Response to Comments- Haven Valley Metropolitan District

PCD PROJECT MANAGER – SERVICE PLAN COMMENTS		
1.	<p>Executive Summary- What is zoning? Is it platted yet? Does it have private roads? Central water and sewer?</p> <p>Repeat comment. Add info.</p>	<p>Revised to include the following:</p> <p>The PUD Development/Preliminary Plan for Haven Valley was recorded on April 26, 2023. It is anticipated that the District will own and maintain all streets identified in the PUD Development/Preliminary Plan. It is anticipated that there will be central water and sewer. It is further anticipated that the Final Plat for Haven Valley will be recorded in July of 2025.</p>

Exhibit A-3
Proposed Infrastructure and Amenities Maps

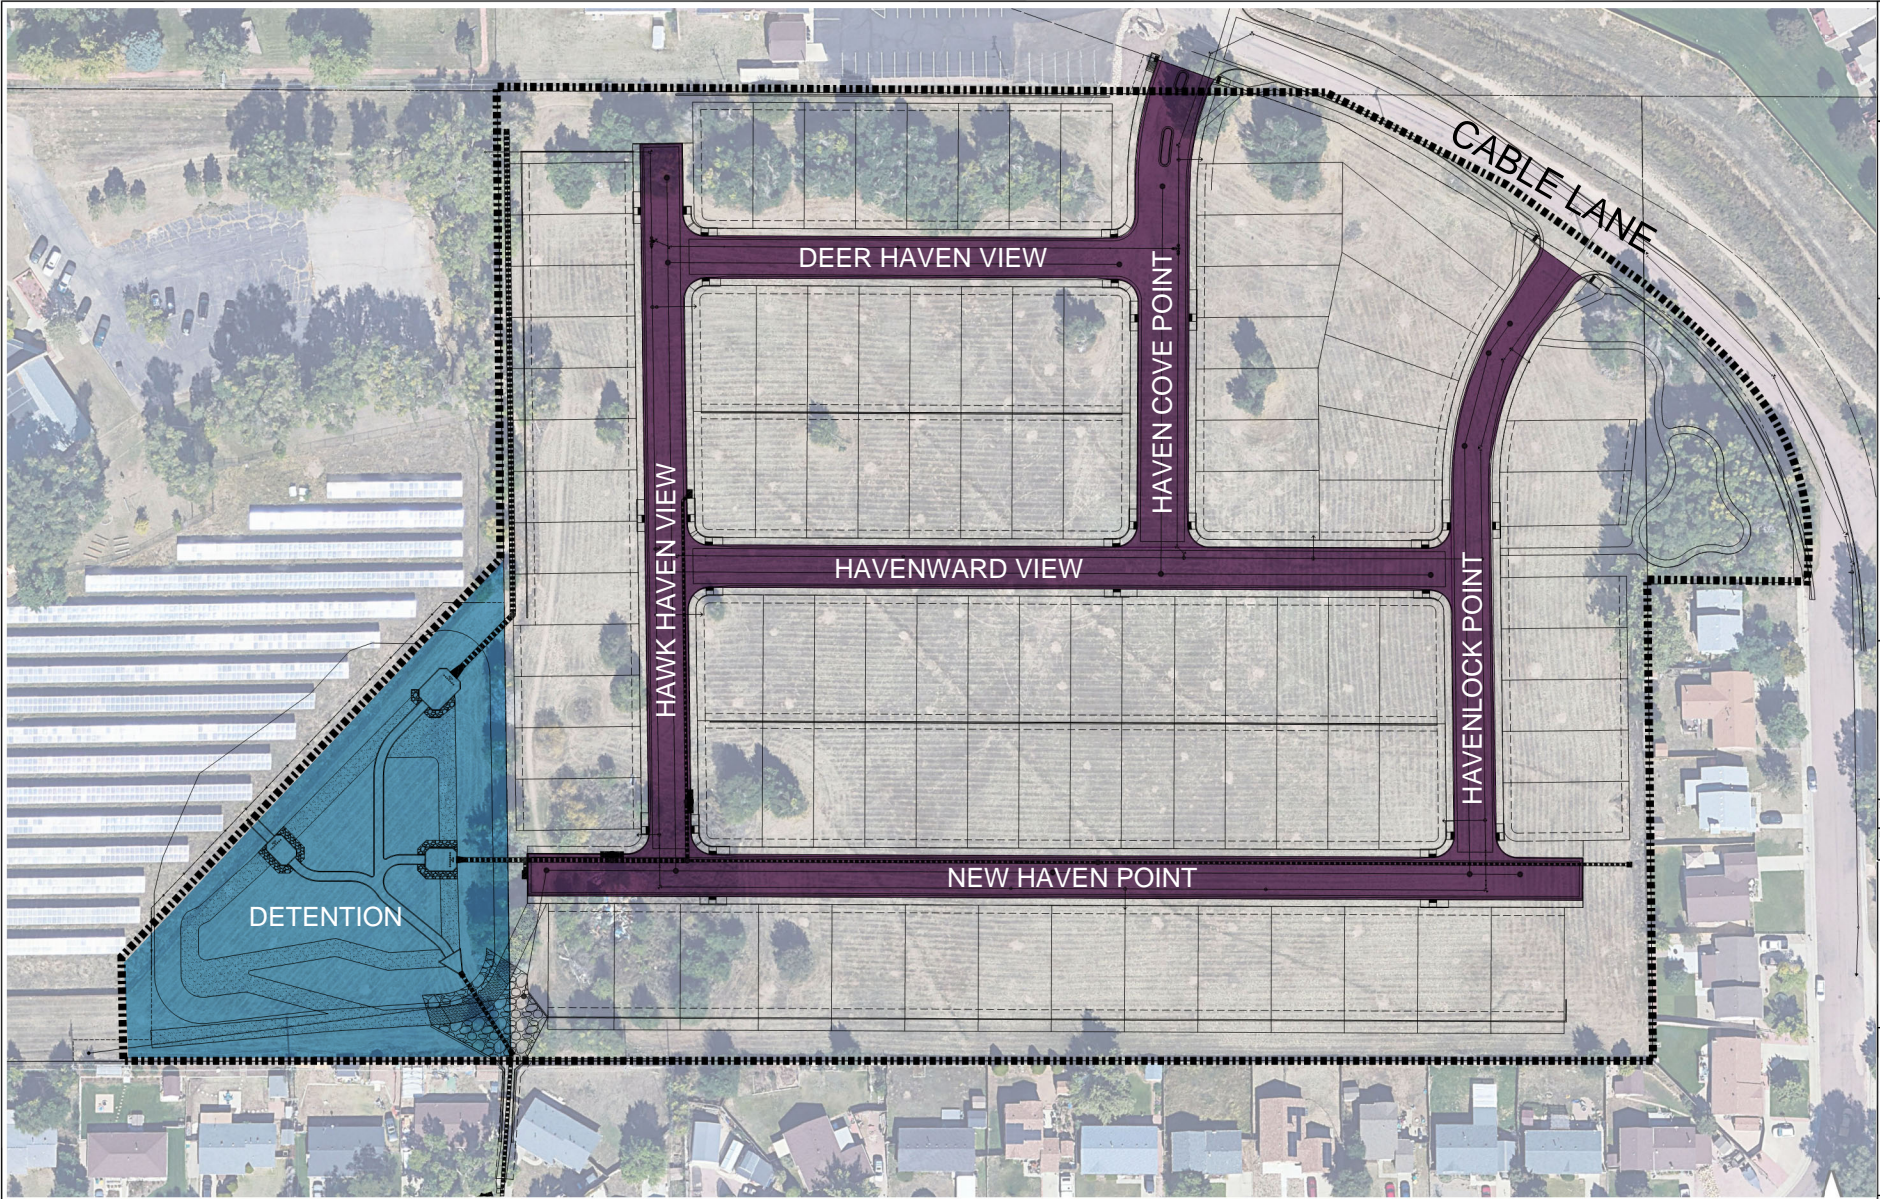
5.	<p>Map. Cable Lane.</p> <p>“These will be improved by this development. Add to map.”</p>	<p>The map states that Cable Lane is a County Road. The map also shows the District road. We added the following statement: “Public improvements to be constructed by the District may include improvements to the existing Cable Lane.”</p>
